Please find below comments and objections to the proposed development for a further 9 dwellings on land to the south of the Hare Hill Croft development site.

The Application ref. is 3\_2022\_0500 for the 9 dwellings to the south of Hare Hill Croft. The application refers to the Permission in Principle (PiP) application 3/2018/0582 and PiP appeal decision APP/T2350/W/19/3223816.

PL 30

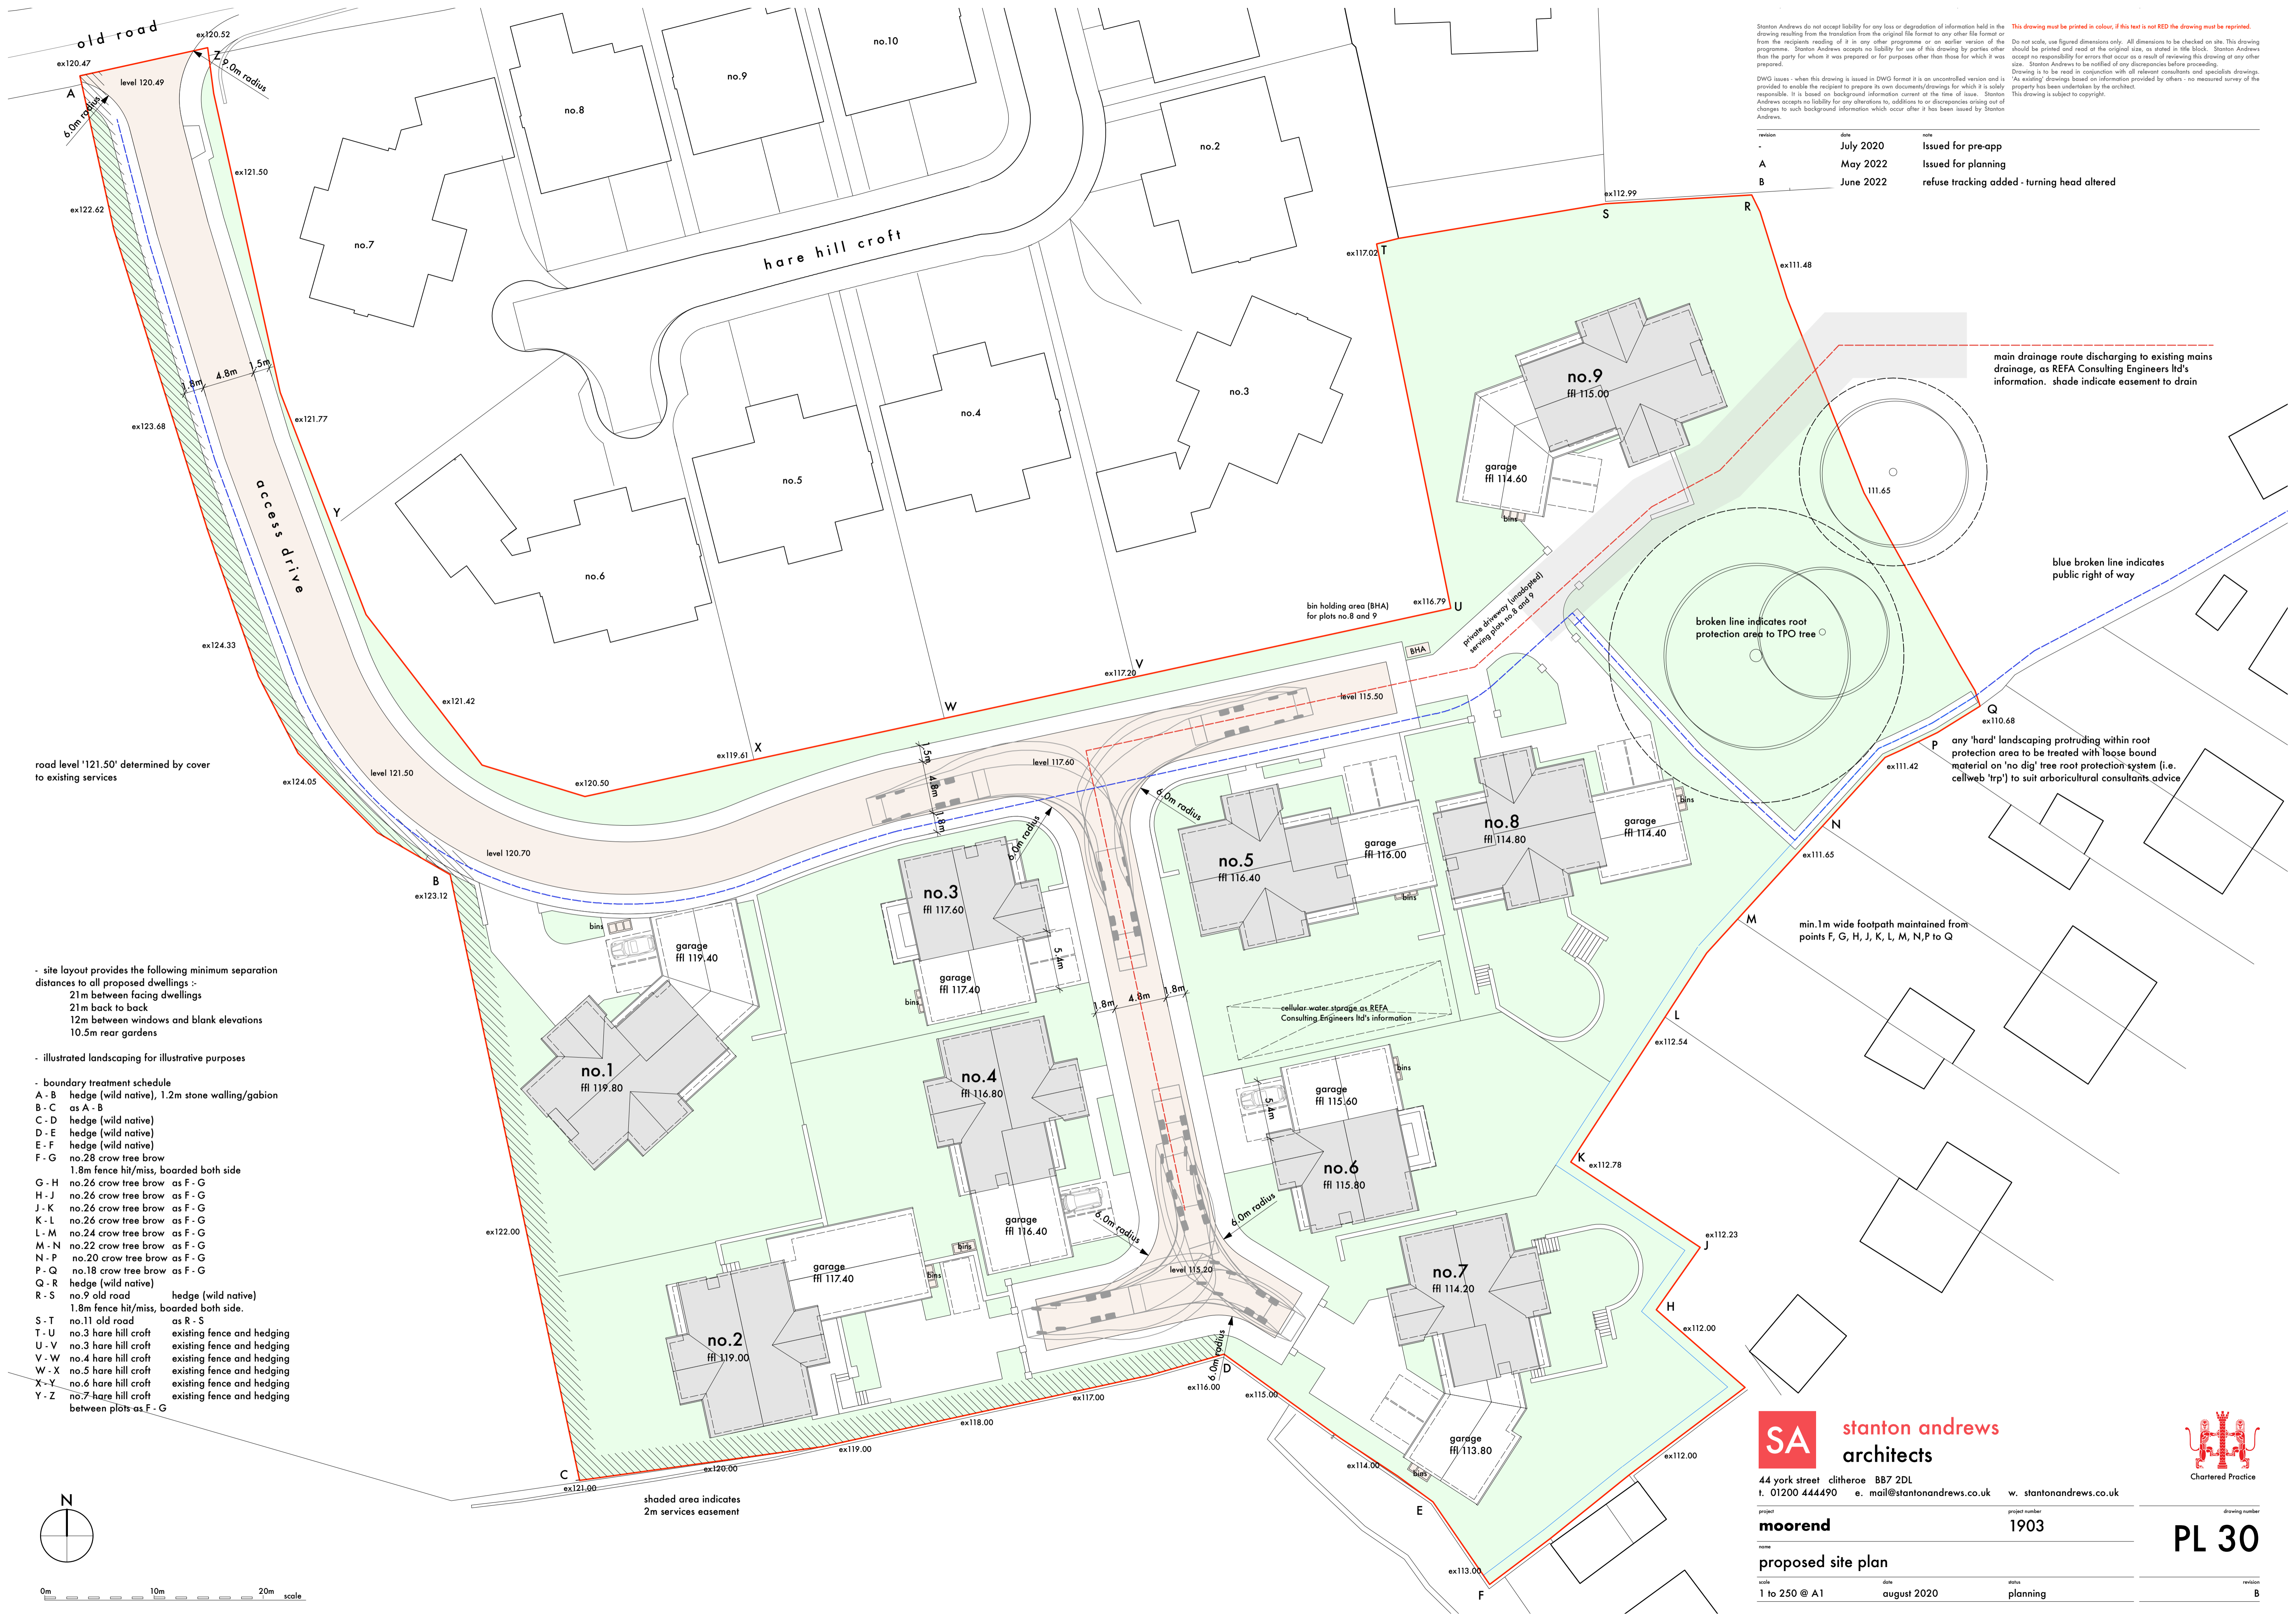
- 10 The proximity and depth of excavation and foundations associated with the proposed development immediately adjacent to the 2m wide services easement as shown on application drawing PL 30 have not been considered or detailed. The 2m wide services easement is an existing easement that accommodated the overhead electricity cables that were diverted as part of the HHC works.

**15 The landscape details show a new hedge along the south side of No’s. 3, 4, 5 and part of No.6 HHC. This conflicts with the HHC landscape which has been in place since 2021 and has not been maintained since installation. Other elements of HHC landscaping along No.2 HHC have still not been completed.**

**17 The proposed site extents are incorrect on the submitted drawings. The red line boundary to the rear garden of No.5 Hare Hill Croft extends in a straight line between the two projecting masonry walls that form the delineation between adjacent HHC properties as shown in extract below land registry extract below. The solid line along the southern boundary of No.5 HHC in the extract below is the original hedge and fence line as surveyed by the Land Registry.**
